**RE: New Office Warehouse for Purvis Industries (E17D041F)
Singer Blvd. & Midway Park Blvd.
Conceptual Grading and Drainage Plan
Engineer Stamp Date: 10-30-15**

Re: New Office Warehouse for Purvis Industries
Singer Blvd. & Midway Park Blvd.
Grading and Drainage Plan

Based on the comments made regarding the drawings submitted 9/2/15, the following addresses those comments:

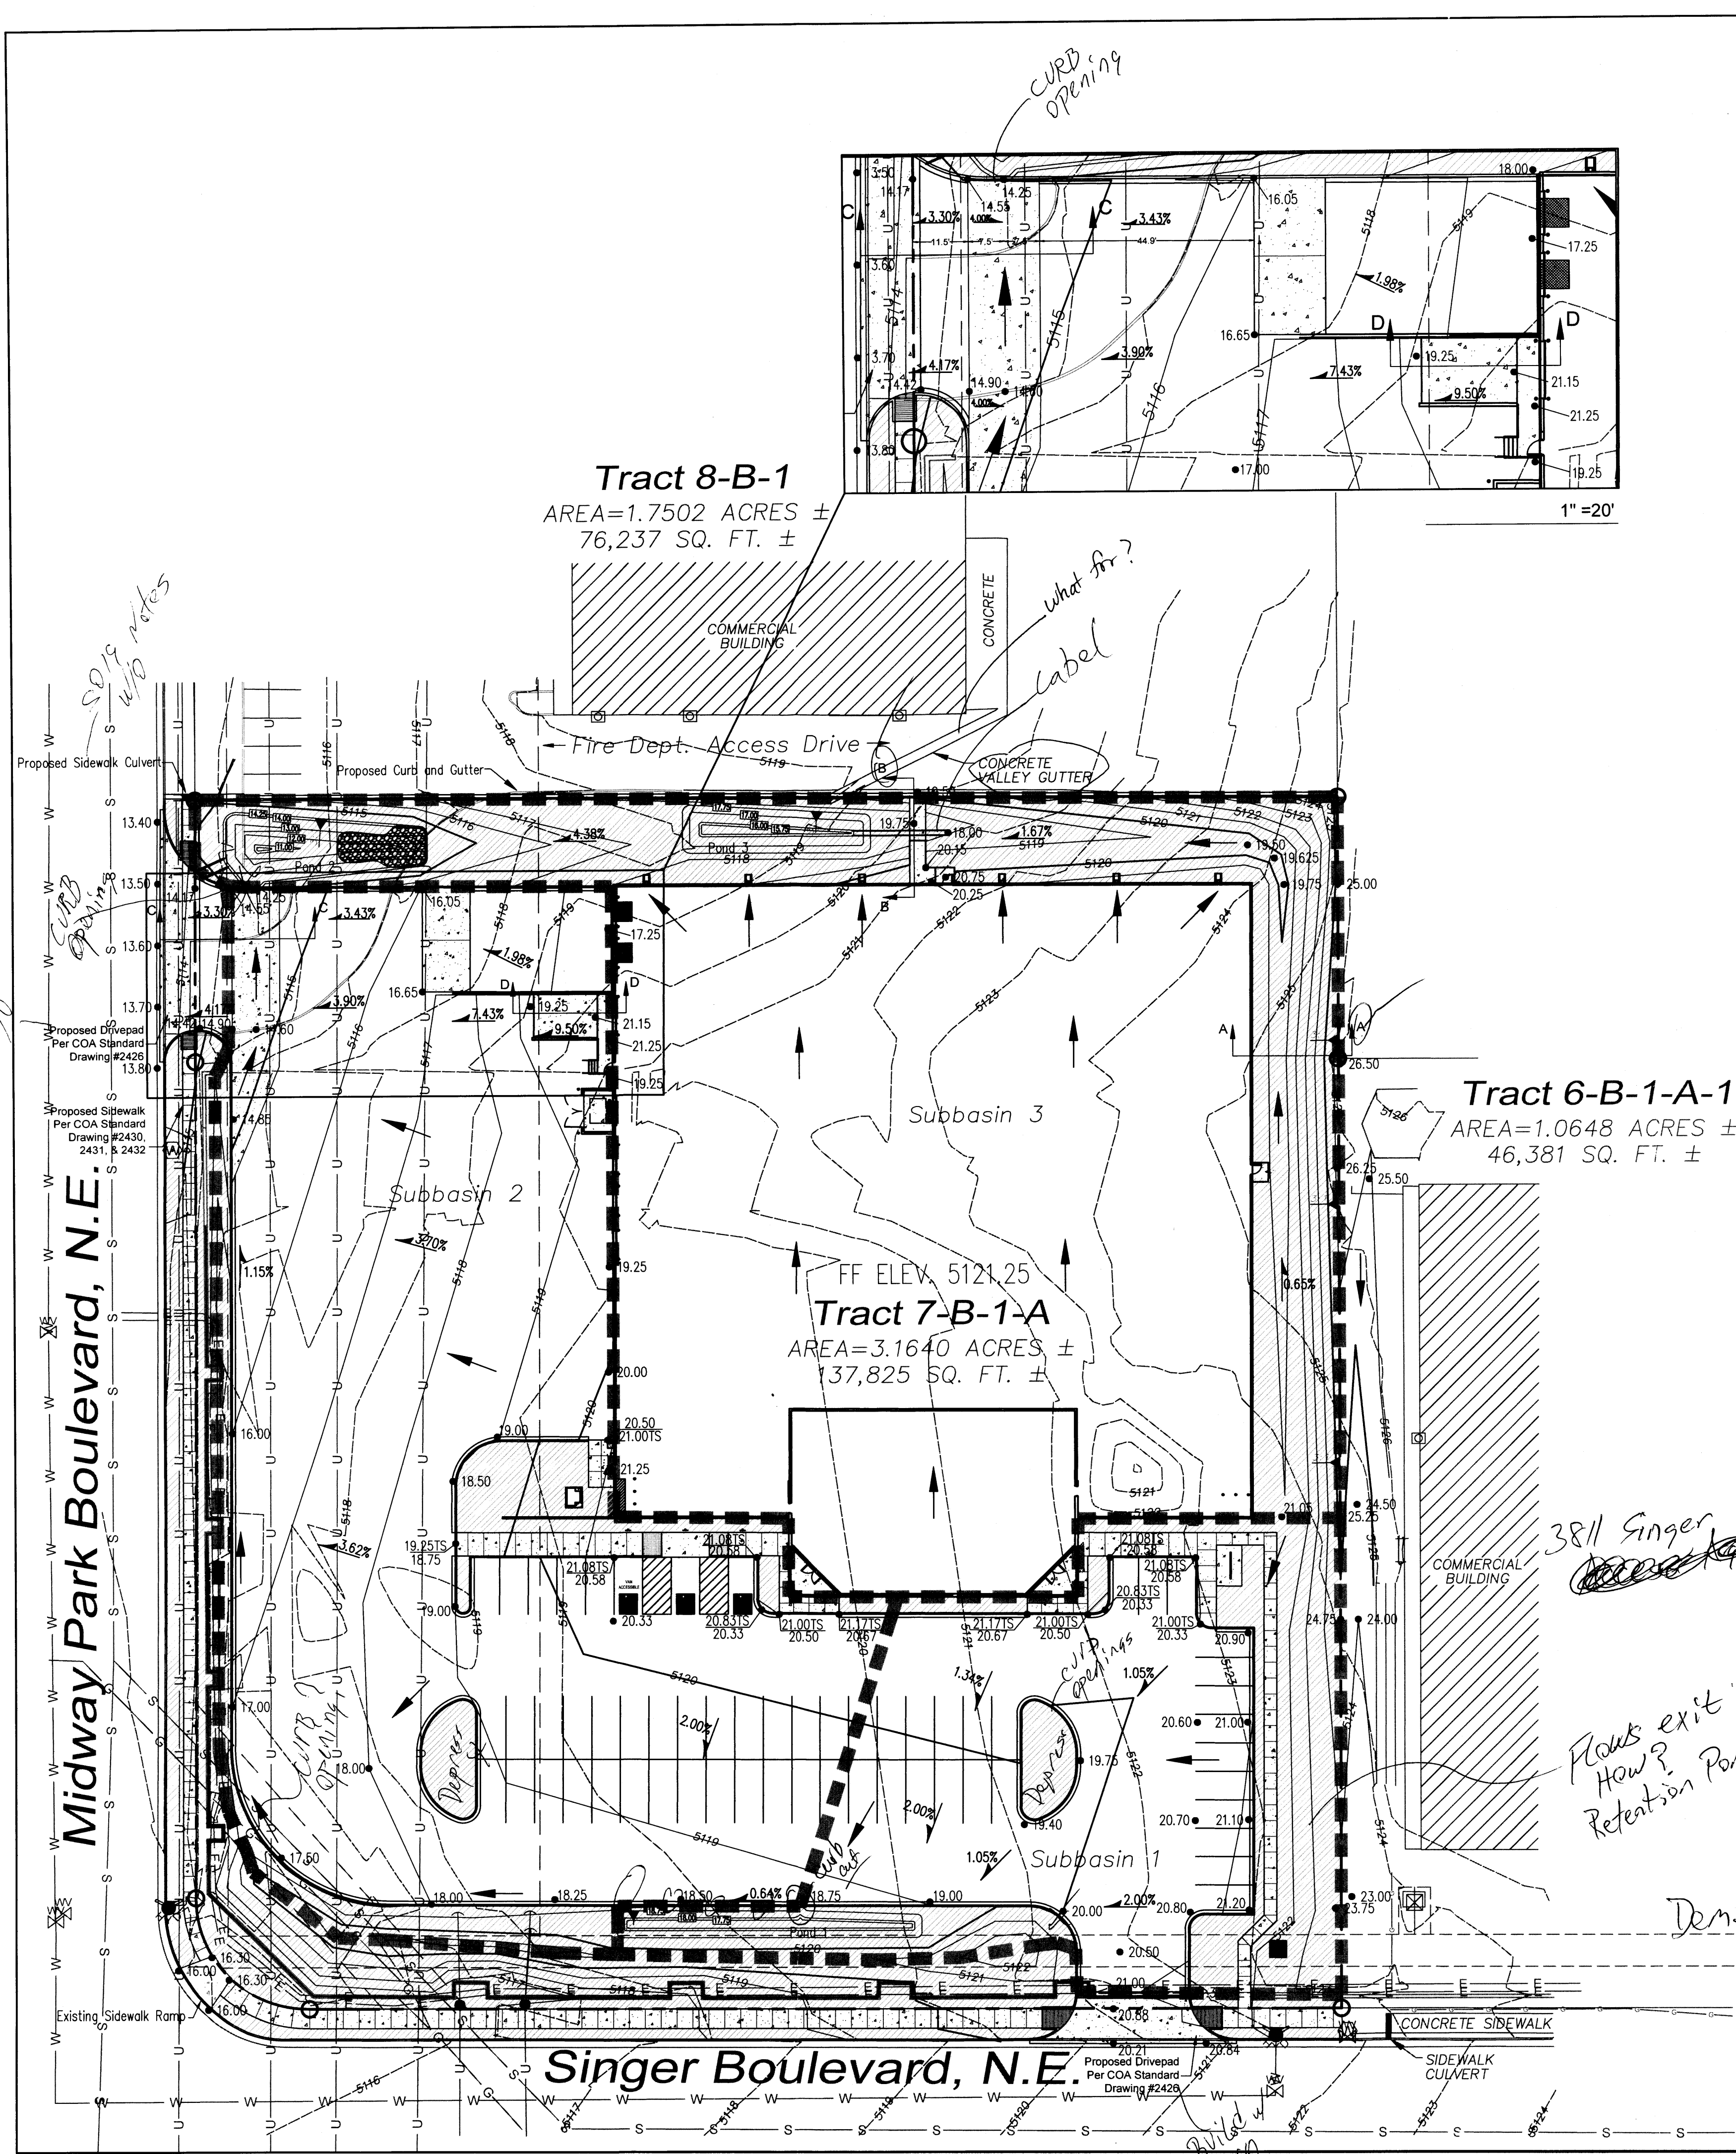
4. An exhibit showing existing and proposed lot lines would be helpful. Also show existing building, and indicate those intended to be demolished.
See updated Grading Sheet (C-2)

11. Show rip-rap or concrete pads below roof drains, and show how discharge will either be directed to Pond 3 or the swale on the east side of the pond.
See updated sheets

12. Call out the 18” pipe culvert on the plan view. Is there sufficient cover for this culvert?
See updated sheets. Yes, there is sufficient cover between the top of the culvert and the bottom of the concrete sidewalk. This area will only see foot traffic and no vehicle loads.

13. Show erosion protection between Pond 2 and 3.
See updated sheets

18. Provide a benchmark

19. Provide build notes/details for the 3' x 0.5' concrete weir and Pond 2.

See updated Grading Sheet (C-2)

See updated Grading Sheet (C-2)

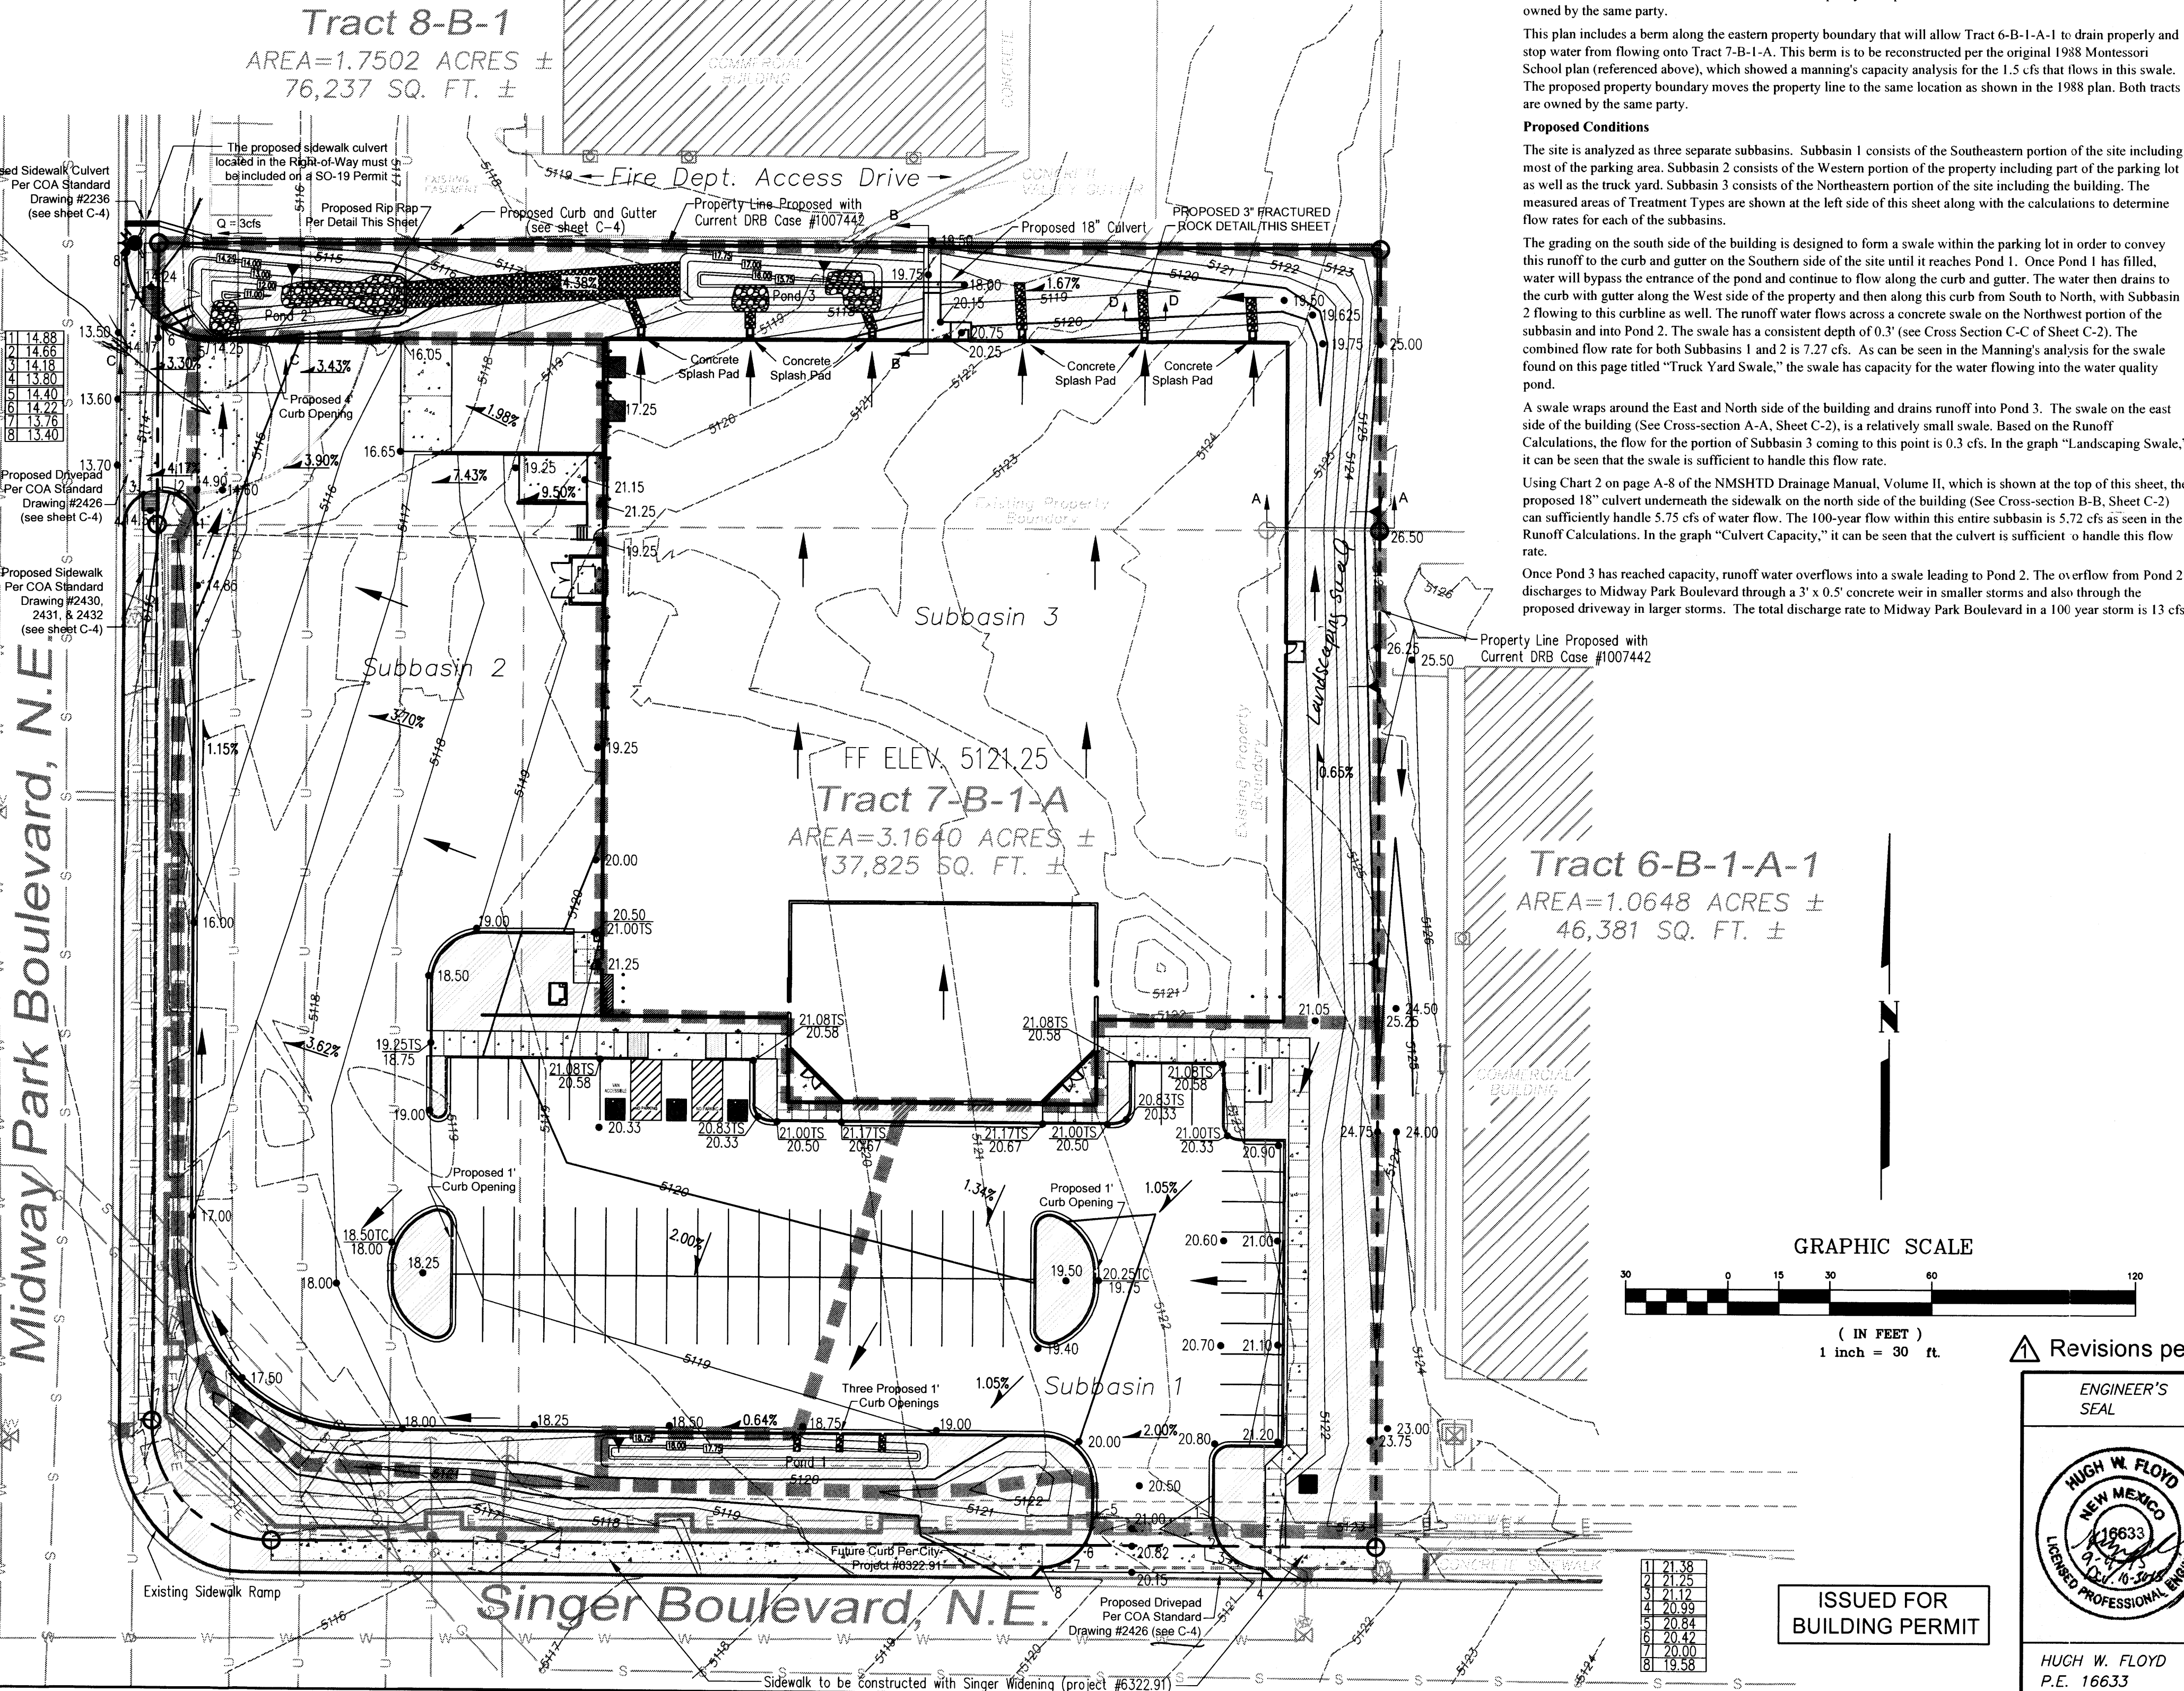
1. In the narrative, indicate the Drainage File number of all reports that are used to research this site, ie. Singer Business Park DMP is E17D041F; Montessori School is also E17D041F
See updated narrative on Drainage Sheet (C-1)

2. The Singer Business Park Drainage Plan (1984) is missing basin maps but the narrative explains the drainage scheme and this information should be summarized in the narrative. Indicate how basin 1-B and 2-B were intended to drain, and how flows ultimately discharged to Midway and then to a channel. Also state the developed discharge from this site, as the downstream channel would have been sized based on this amount.
See updated narrative on Drainage Sheet (C-1)

3. The Montessori School Drainage Plan (1989) is referenced in the narrative and states that the site was developed according to the plan. However, comparison of aerial views to the plan do not match. What portions of this plan were constructed? How do present day lot lines compare to those of this plan? What happened to the concrete alley gutter which accepted flows from the lot to the east? Is it not evident in the aerial view? How much flow did it accept? What was the discharge?
Please see the plans for the Montessori School Drainage plan from 1988 for existing conditions. The plans from 1989 were not constructed. The lot lines were adjusted for the plans made in 1988, however, since this construction never occurred, the lot line is simply returning to where it is located in the 1988 plan set. The narrative has been modified for clarity.

5. Provide information or excerpts from the lots to the east (F17D058 and F17D054) to determine how the drainage of these lots will be directed south through the new swale. The last paragraph of the narrative should be labeled “OFFSITE FLOWS” and be presented before “Proposed Conditions” in the narrative. Since existing off site flows to the east are intended to flow south to the existing SW culvert, show that the swale and existing SW culvert have sufficient capacity.
See updated narrative on Drainage Sheet (C-1)

6. How much flow will be directed from the existing valley gutter to the north (Lot 8B) to the proposed SW Culvert? Show capacity calculations for the SW culvert.
See updated sheets

7. Provide calculations to determine the amount of First flush that must be retained for each sub-basin.
See updated sheets (Drainage, left side under “Water Quality First Flush Volumes Required”)

8. Calculations for concrete swale at NW entrance show 0.3 cfs, but the peak flow rate is 7.27 cfs. Verify the swale is sized correctly.
See updated sheets. The 0.3 cfs calculations were in reference to the critical cross-section (A-A) in the landscaping swale. This has been made more specific in the narrative.

9. Pond Volume calculations need only be to 2 significant digits.
See updated Drainage Sheet
10. How will the “first flush” from sub-basin 1 enter Pond 1? Show openings intended to direct flows to both Pond 1 and 2.
See updated sheets
